Response to Submissions Report

21, 31 and 42 Hanson Place, Eastern Creek
Resource Recovery Facility

Submitted to NSW Department of Planning,
Industry and Environment
On behalf of Hanson Construction Materials Pty
Ltd

2 December 2021 | 218611

Title
 Site Plan
 Resource Recovery Facility
 Lot 3, 4 & 5 DP 1225803
 Hanson Place, Eastern Creek
 Alex Fraser Group

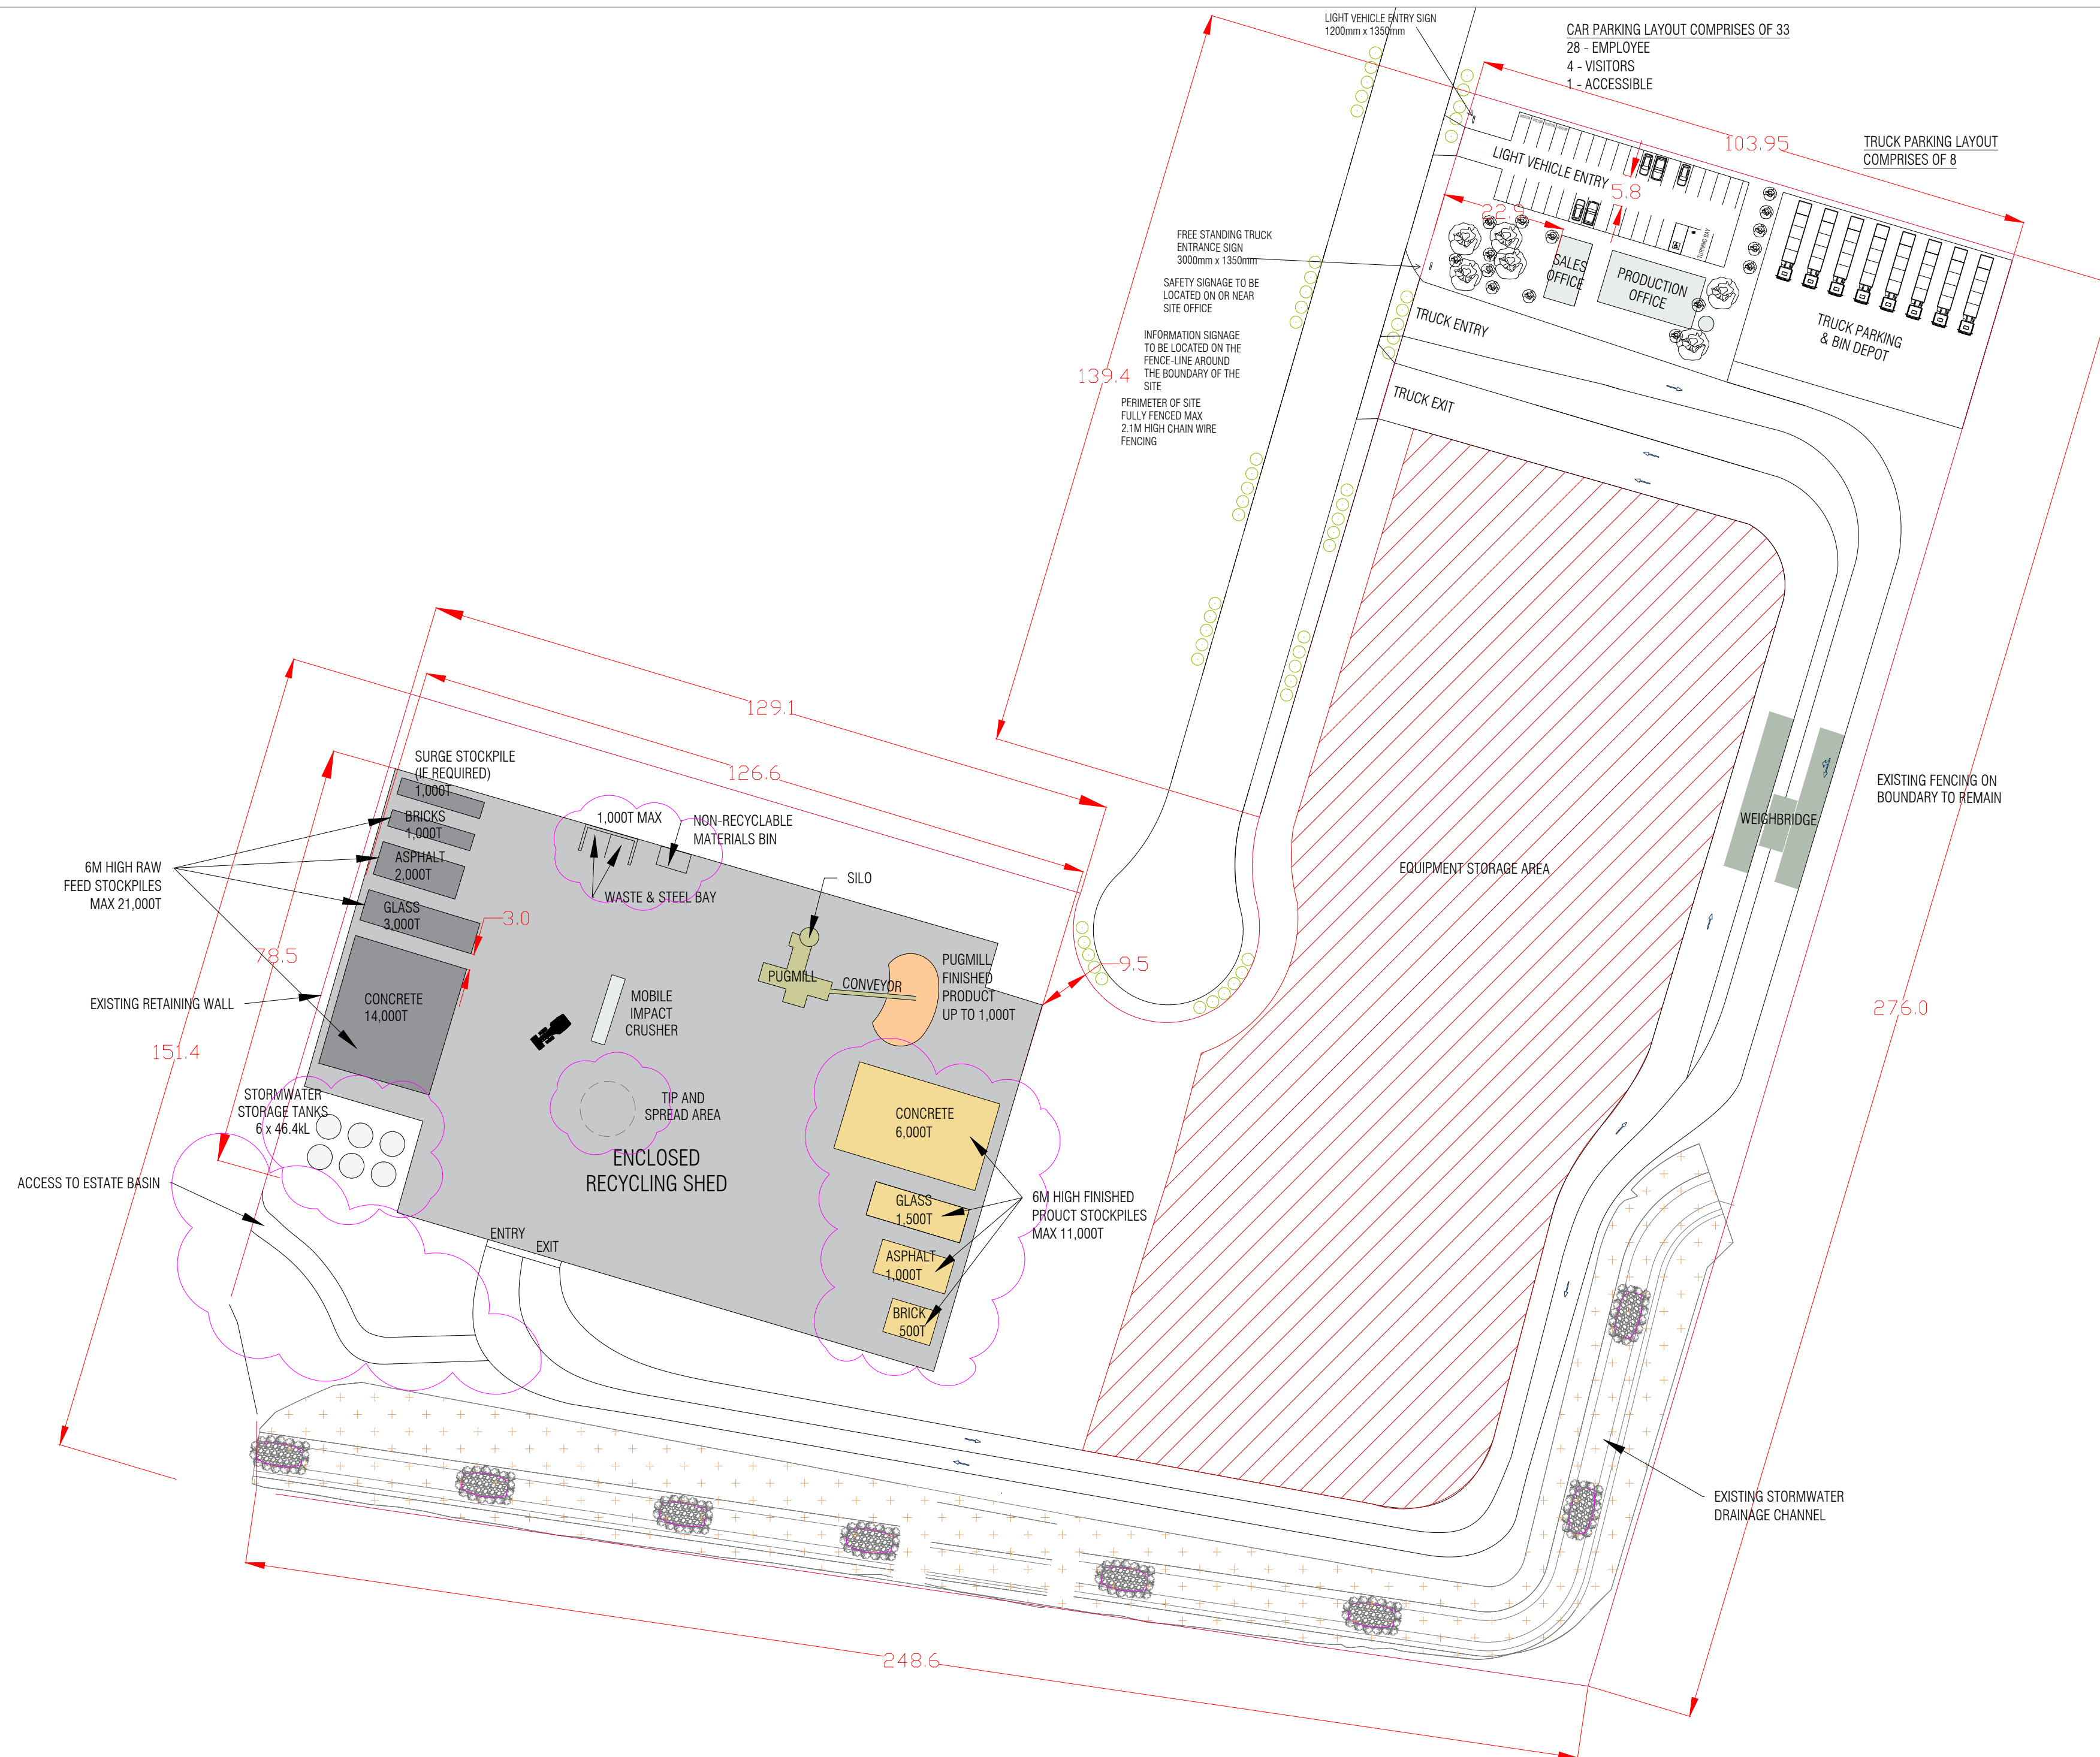
- Provision has been made for access to the estate-wide basin, as requested by Blacktown City Council.
- Above ground stormwater tanks have been relocated to the south-west corner of the shed.
- Reconfiguration of the shed layout to include waste, steel and non-recyclable materials bins.

- Additional information is requested regarding the size and nature of proposed signage.
- Above-ground stormwater storage tanks are non-compliant with the 7.5m front setback control under the Eastern Creek Precinct Plan (Stage 3) Development Control Plan.
- Justification is to be provided for the proposed 24/7 hours of operation.
- A draft Plan of Management has not been provided as to the emergency actions in the instance where contaminated materials are brought to the facility for processing.
- Photomontages have not been provided as requested.

- An Engineering Plan in accordance with Council's Engineering Guide for Development 2005.
- Access to the water quality/OSD basin as approved in the original subdivision is to be illustrated on plans.

DRAINAGE PLAN SHEET 2

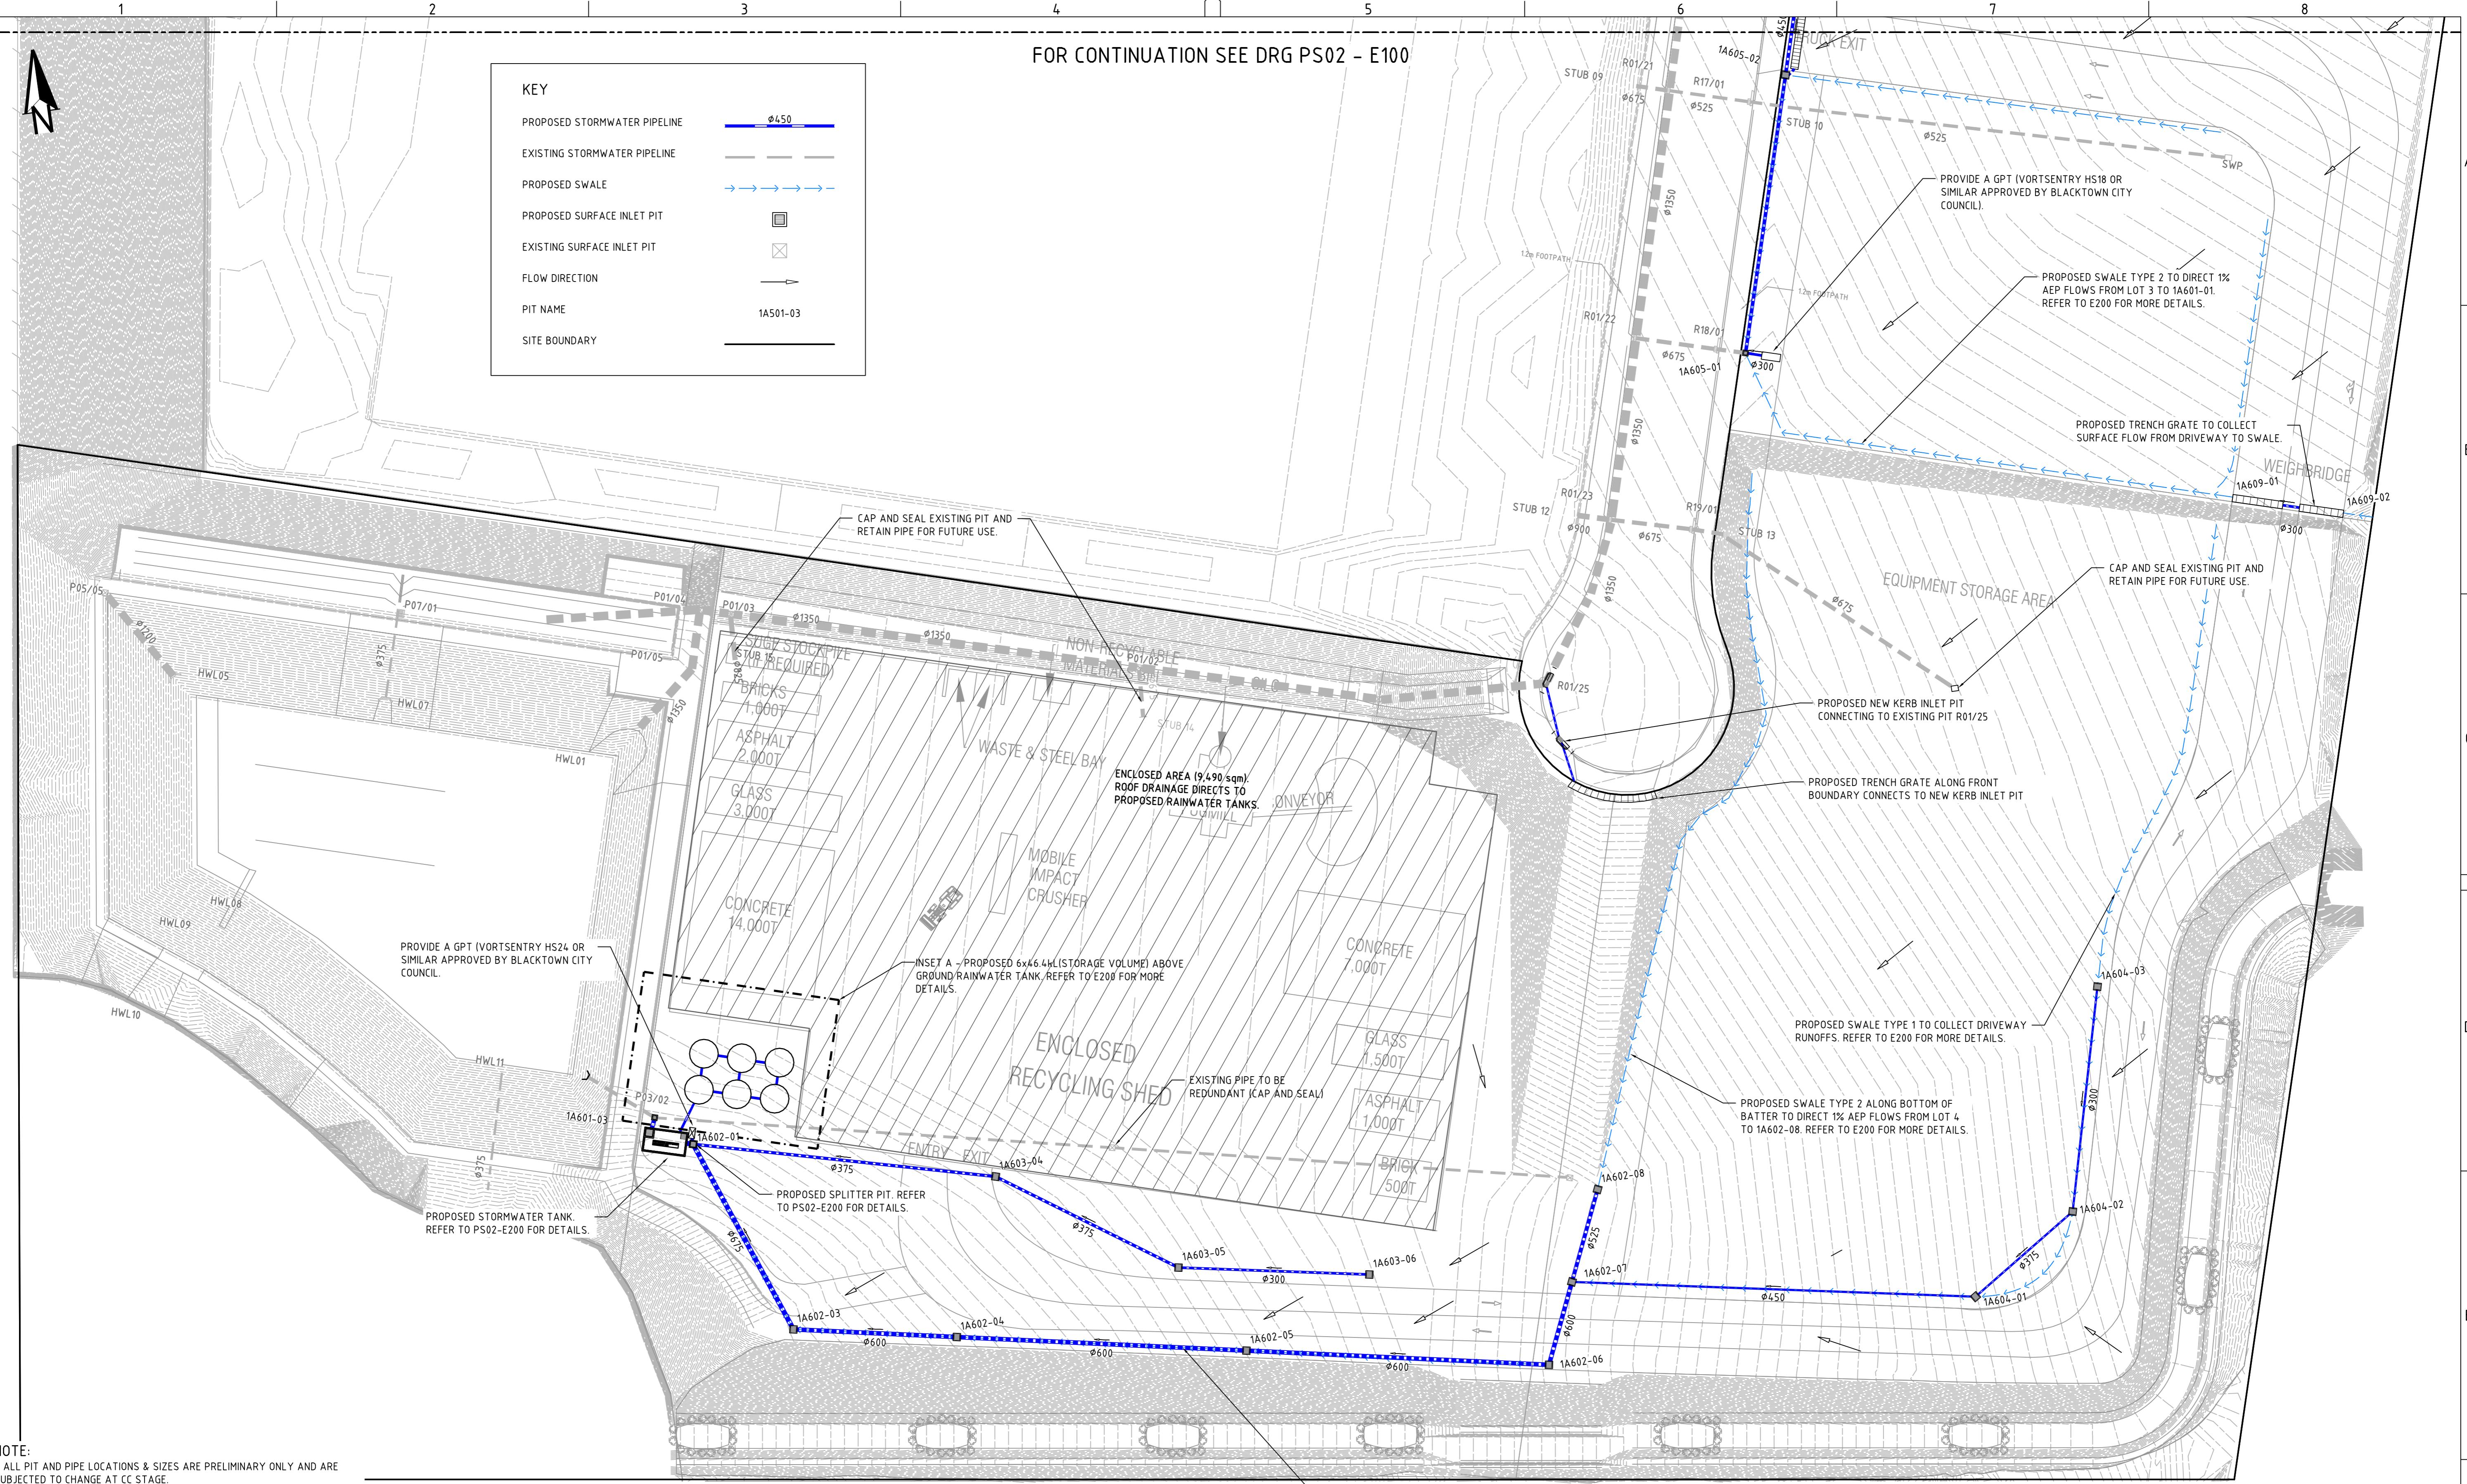
- The concept plans by Martens were unacceptable. Detailed Engineering Hydraulic Plans are required.
- Plans to assume equipment storage areas are paved.
- The number of inlet pits to be increased.
- Trenched grates and pits to be piped to the GPT.
- Combination of trench grates and pits are required for the ramp down from the end of the cul-de-sac. This is to be illustrated on plans.
- Overflow from RWT is to discharge to a stormwater tank if provided, or otherwise directed to the wetland.
- Engineering plans to detail flows discharge from Lots 3, 4 and 5 to the wetland/OSD system.

- Show all pits to be numbered on the plans.
- Show all pit sizes and levels on the engineering plans.
- Drainage plans to be at a suitable scale that is legible at size A3.
- Provide drawing scale and scale bar on the plans.
- Provide suitable RLs across the site surfaces and floor areas on the plans.
